DECISION DELEGATED TO DEVELOPMENT MANAGER

Application No: H06-0728-19 **Applicant:** Ms E Hazell
Proposal: Proposed Extension
Location: Winford Dockings Holt Long Sutton
Terminal Date: 23rd September 2019

Drawing Title: Proposed Block Plan

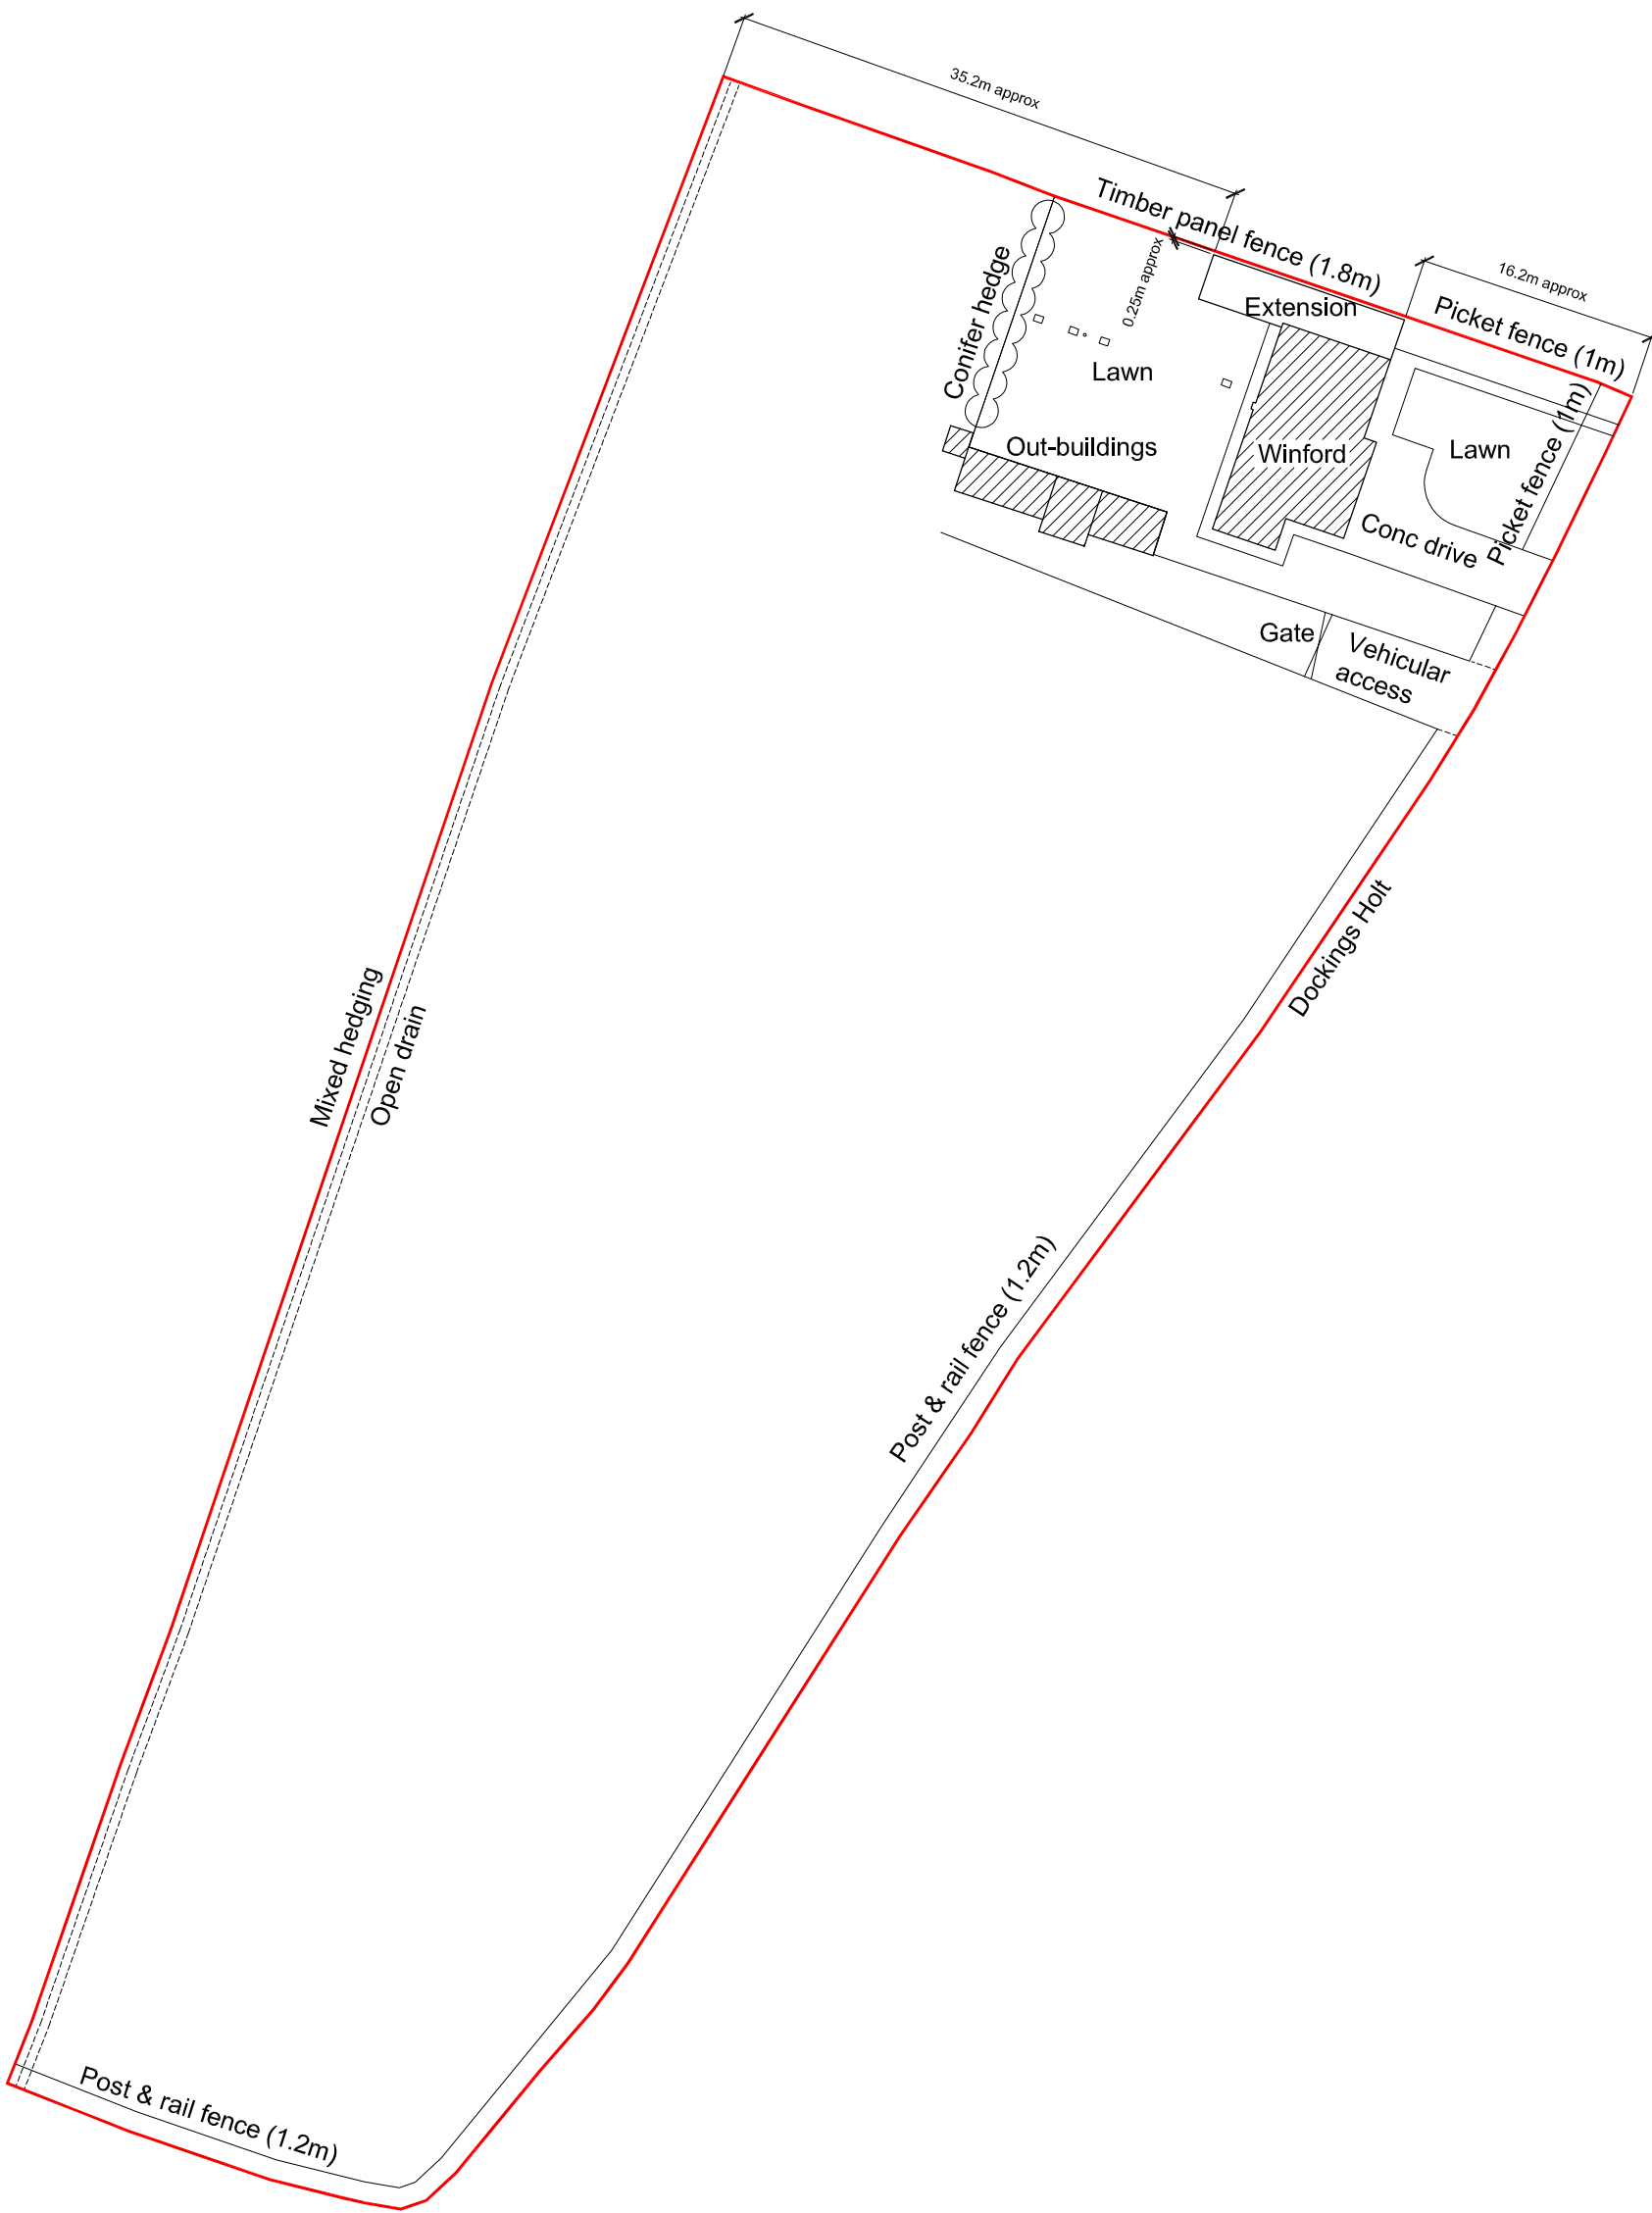
Although there would only be approx. 0.25m between the northern elevation of the proposed extension and the northern boundary, access to the rear of the property would still be maintained along the southern side of the dwelling. Given that the dwelling is sited within a good size plot, it is not considered that the proposed extension would result in a cramped form of development.

The proposed extension would be marginally separated by 0.25m from the existing timber close board fence on the northern boundary. No fenestration has been proposed on that side of the extension. Therefore, no overbearing impact of the fence upon the house occupiers would be existent.

Project:	Winford Dockings Holt Long Sutton Lincolnshire
Drawing Title:	Proposed Ground Floor Plan & Roof Plan

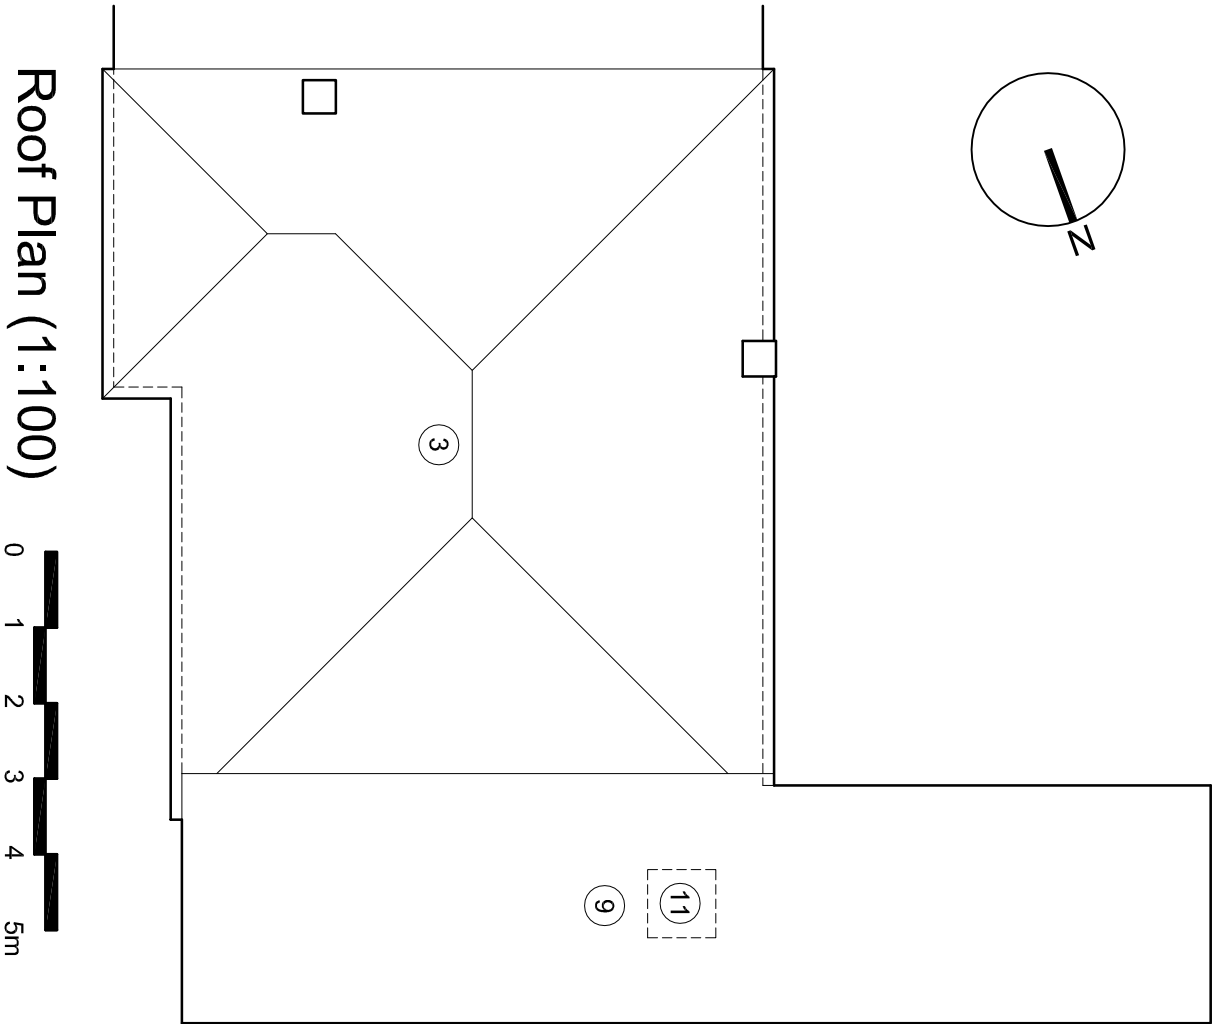
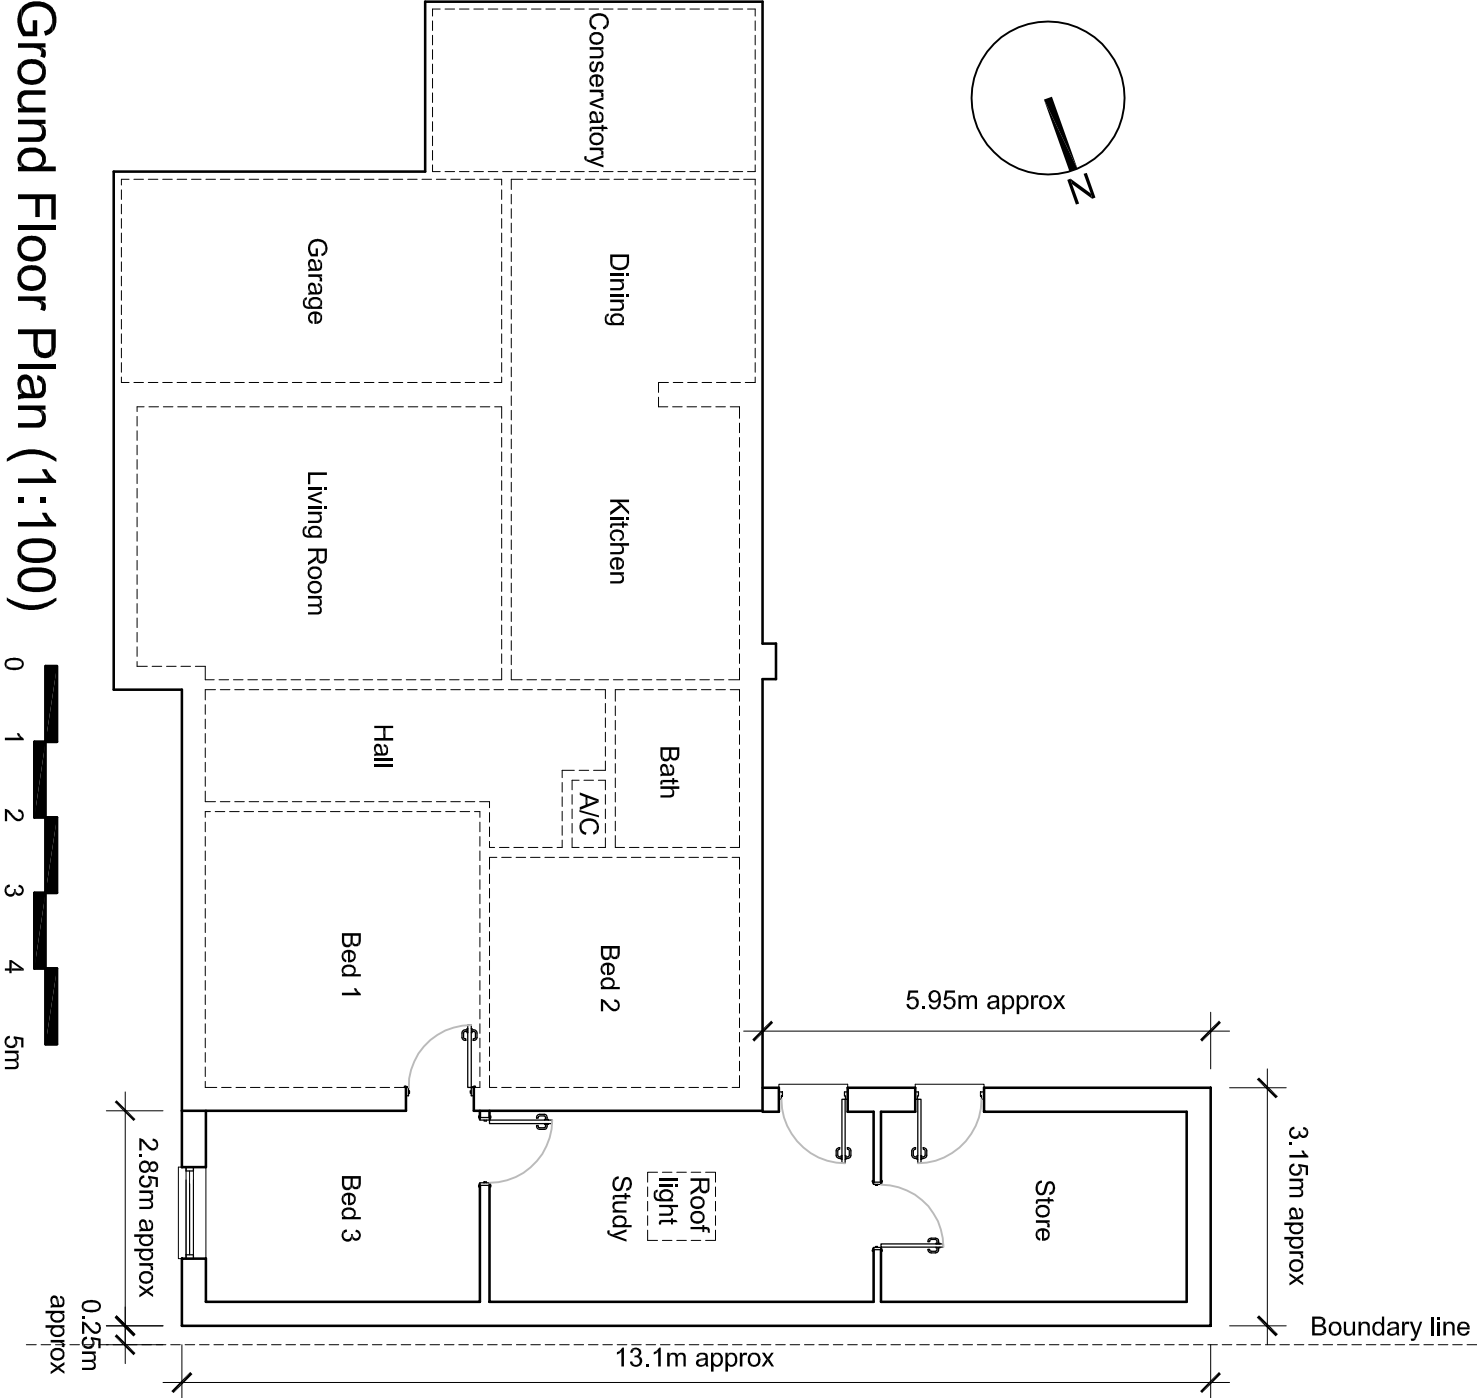
The floor plans show that the aim of the development is to accommodate one additional bedroom, a study room and store. Given the scale and nature of the building, it is considered that the purpose of the development is in line with the existing.

A very slightly pitched roof would cover the extension which would mark the subservience of the development to the host property. A roof lantern would be over the middle of the study room. This element would enhance the enjoyment of daylight for the study users. Two doors have been provided in order to serve access from the house and the rear garden and vice versa. The design and layout of the proposal overall responds well to the site features, existing building and intended use.

Project:				
Winford				
Dockings Holt				
Long Sutton				
Lincolnshire				
Drawing Title:				
Proposed Elevations				
Client:				
Ms E Hazell				
Drawn:				
AMW	AMW	24.07.19	1:100	A3
Job No.:	PD105	Stage:	Planning	Revision:
111801	PD105	Planning		P1

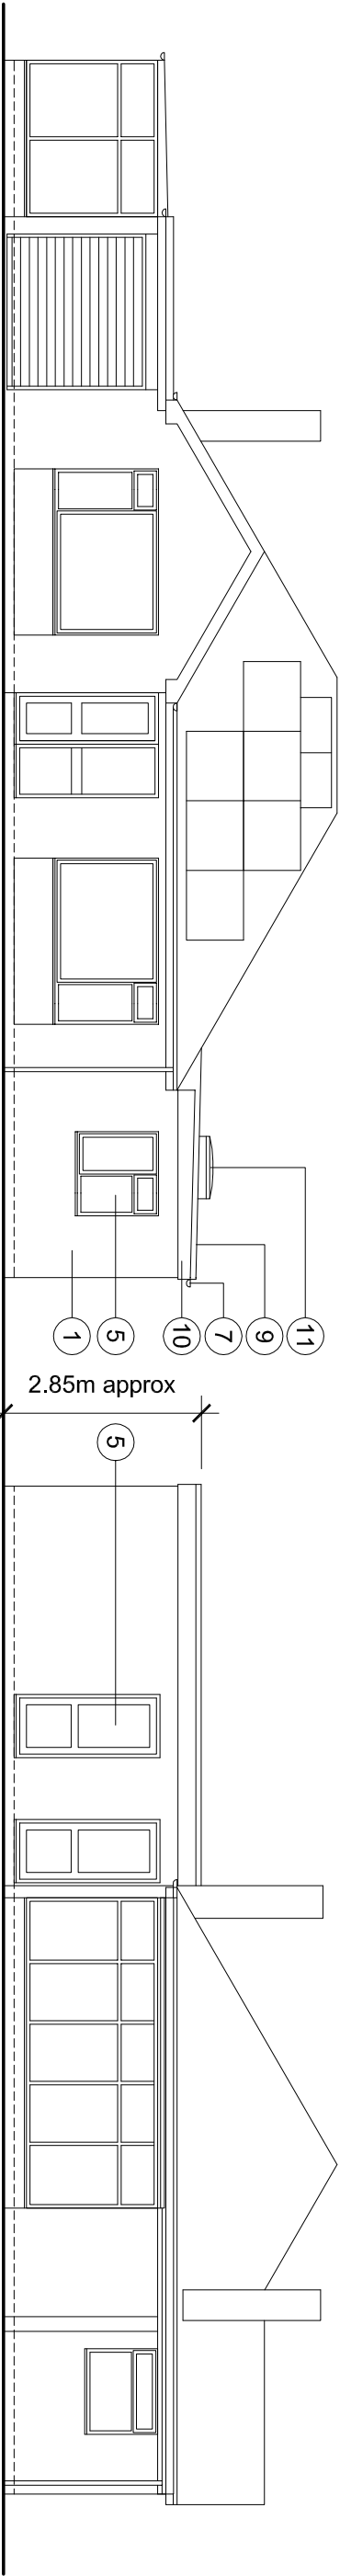
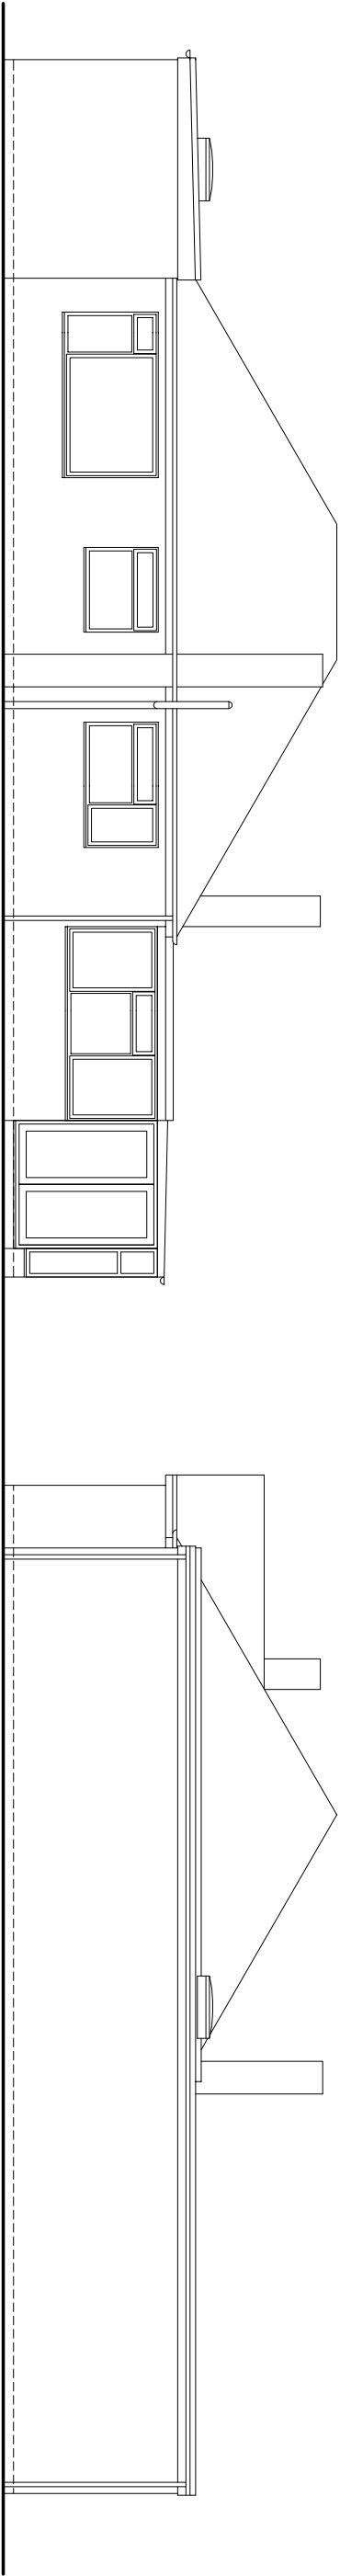
The proposed extension would protrude approximately 2.85 metres from the northern side elevation of the house. It would measure roughly 13.1 metres in depth from the front elevation. The maximum height would be nearly 3 metres. Having regard to the dimensions of the house, the development is therefore subservient to the host property in terms of scale, mass and bulk.

With regards to the external materials, facing brickwork to match existing as closely as possible would be used for the walls. Glass reinforced plastic (GRP) differs from the existing concrete interlocking roof tiles in the house although both share the grey colour. New fenestration would be made of white UPVC matching with the existing windows and doors. On balance, the resulting appearance of the development in light of the proposed materials would be in keeping with the existing visual amenity.
